**COCHLEAR GLOBAL HEADQUARTERS – MACQUARIE UNIVERSITY**  
**PROJECT APPLICATION**  
**RESPONSE TO SUBMISSIONS**

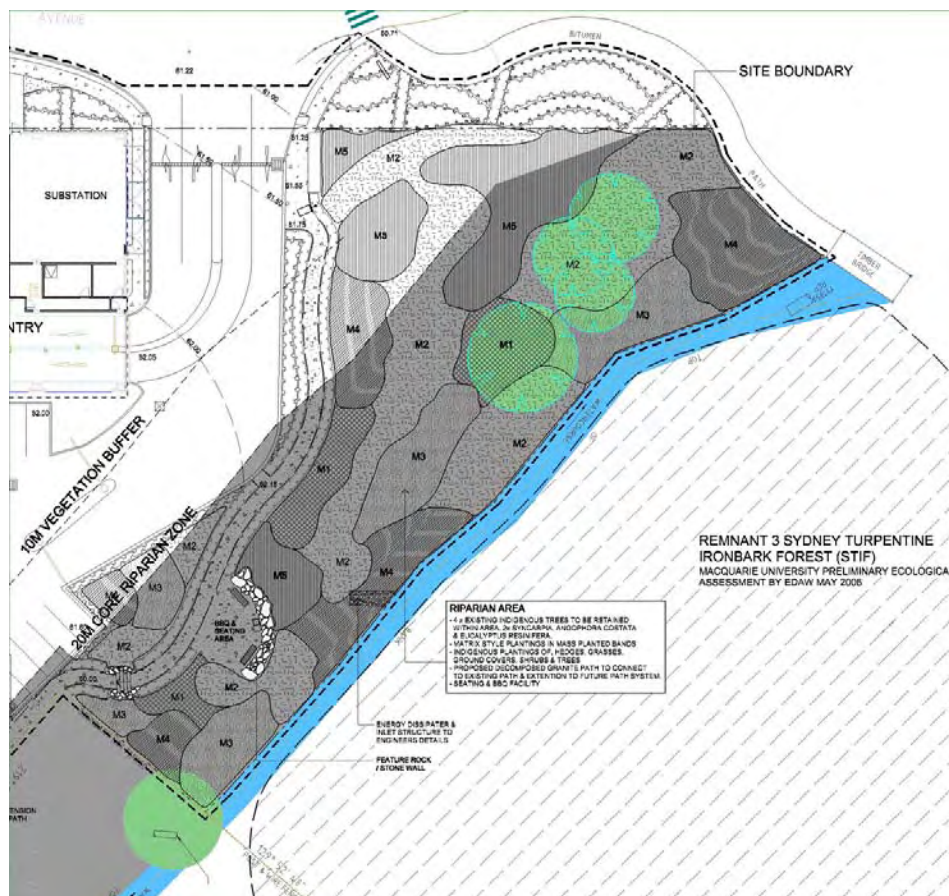
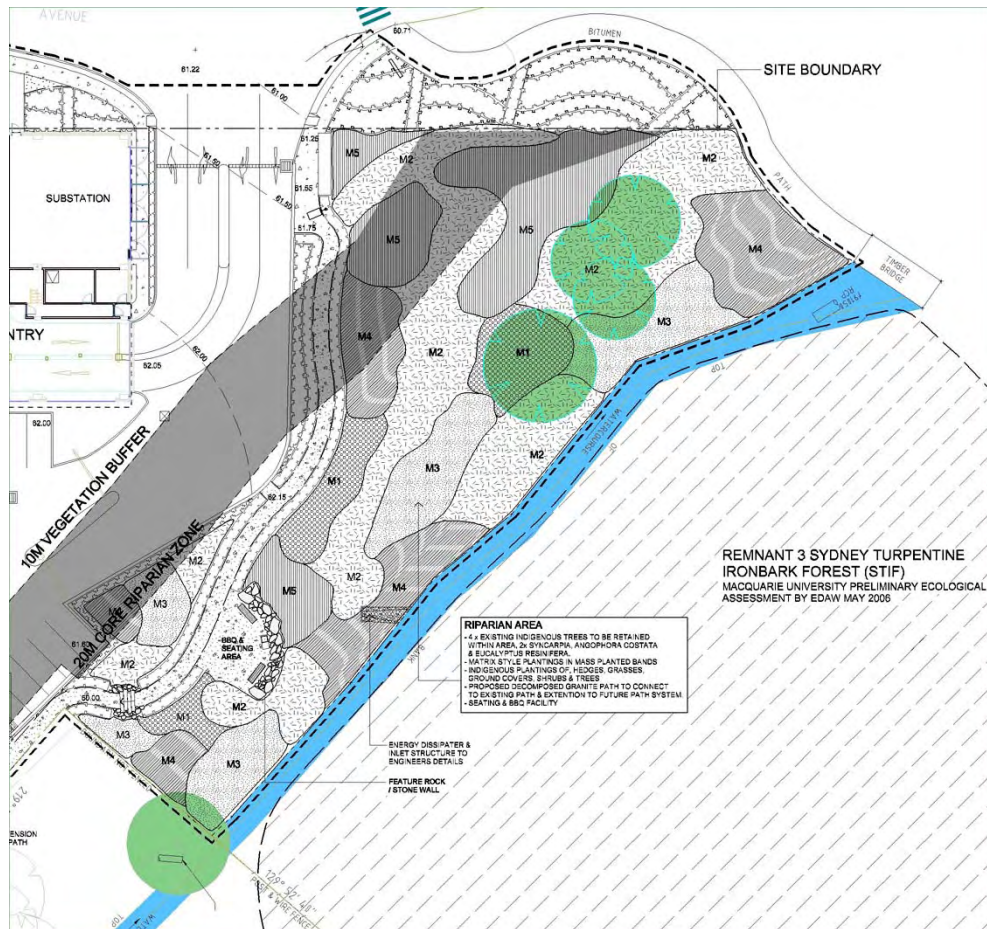
KEY ISSUE / SUBMITTOR	COMMENTS MADE	RESPONSE
Department of Planning	e) Confirm whether the NSW Department of Water and Energy specifications for a riparian buffer are being complied with.	<p>e) The project complies with the intent of the NSW Department of Water and Energy specifications for the riparian buffer. A Vegetation Management Plan (VMP) Report has been prepared for the project and submitted in accordance with the Guidelines for controlled activities. The VMP addresses the specific requirements of the Department of Natural Resources (DNR), as outlined in “DNR Guidelines for Controlled Activities Vegetation Management Plans: March 2007”. It firstly identifies the extent of the riparian zone and the Department of Water and Energy (DWE) requirements.</p> <p>DWE has sought a Category 2 outcome, which is a 20 metre wide core riparian zone (measured from top of bank) plus a 10m wide vegetated buffer.</p> <p>DWE has previously acknowledged that there are existing pinch points along University Creek, and that there may be some flexibility with the riparian corridor width to accommodate the new development as pinch points. DWE has stated that, based on the guidelines and application of a pinch point approach, the proposed design conforms with the riparian buffer guidelines/specifications.</p> <p>The project has been designed for a 20 metre wide core riparian zone with a 10 metre wide vegetated buffer adjacent University Creek with some pinch points.</p> <p>Please see DEM’s response to this issue attached.</p>

CYCLING REQUIREMENTS

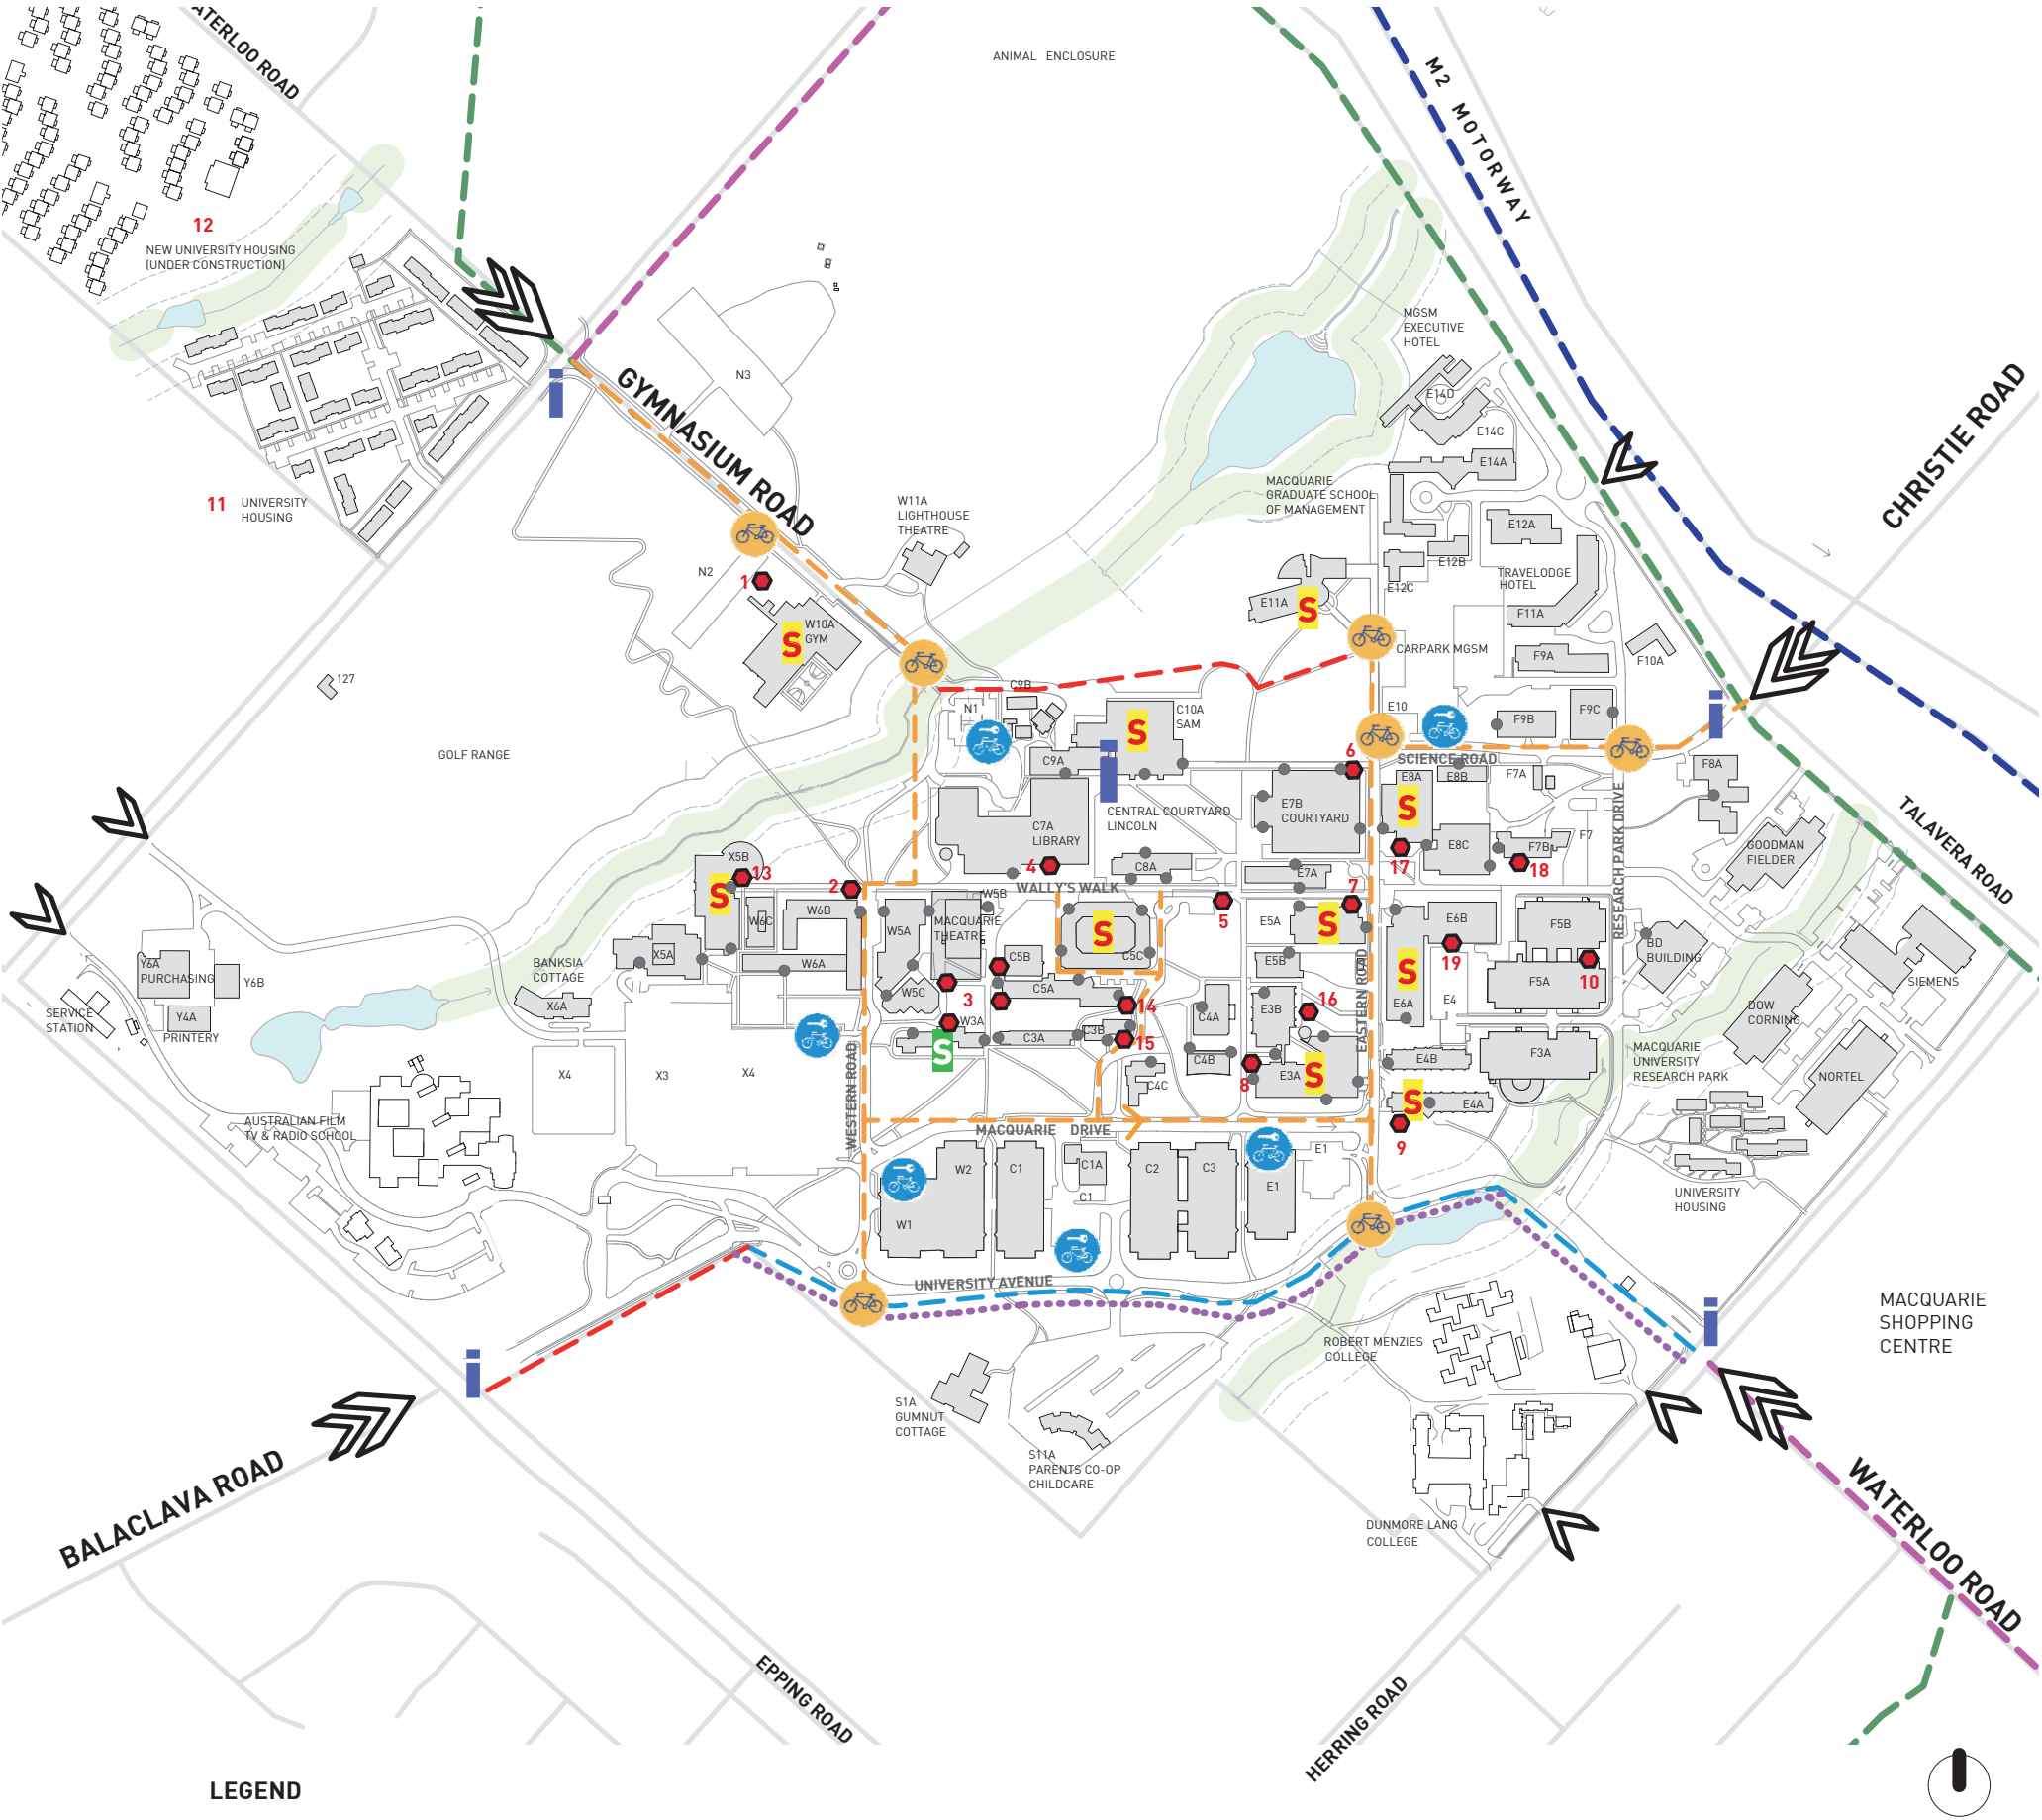
6. The provision of cycle access to the subject site along University Avenue is not clear within the proposal. Given the high level of proposed bicycle parking a more detailed design approach is required, which builds on the Macquarie University Concept Plan.	<p>6. Parking for 152 bicycles will be provided at the Cochlear development. This facility will be conveniently accessed and supported by a changing facility. The cycle storage will be covered and monitored by CCTV and additional measures to encourage cycling will be included in the WPTP.</p> <p>To assist staff to use sustainable travel from the first day of occupation, consultation will be undertaken with the University regarding the early implementation of the proposed off-road segregated bicycle path along University Avenue as shown in Short Term Option of the Macquarie University Bicycle Network Masterplan. Refer to attached plan in the letter by the Director of the Office of Major Projects at Macquarie University attached to this document.</p> <p>Please see Cardno Eppell Olsen's detailed response as attached.</p>
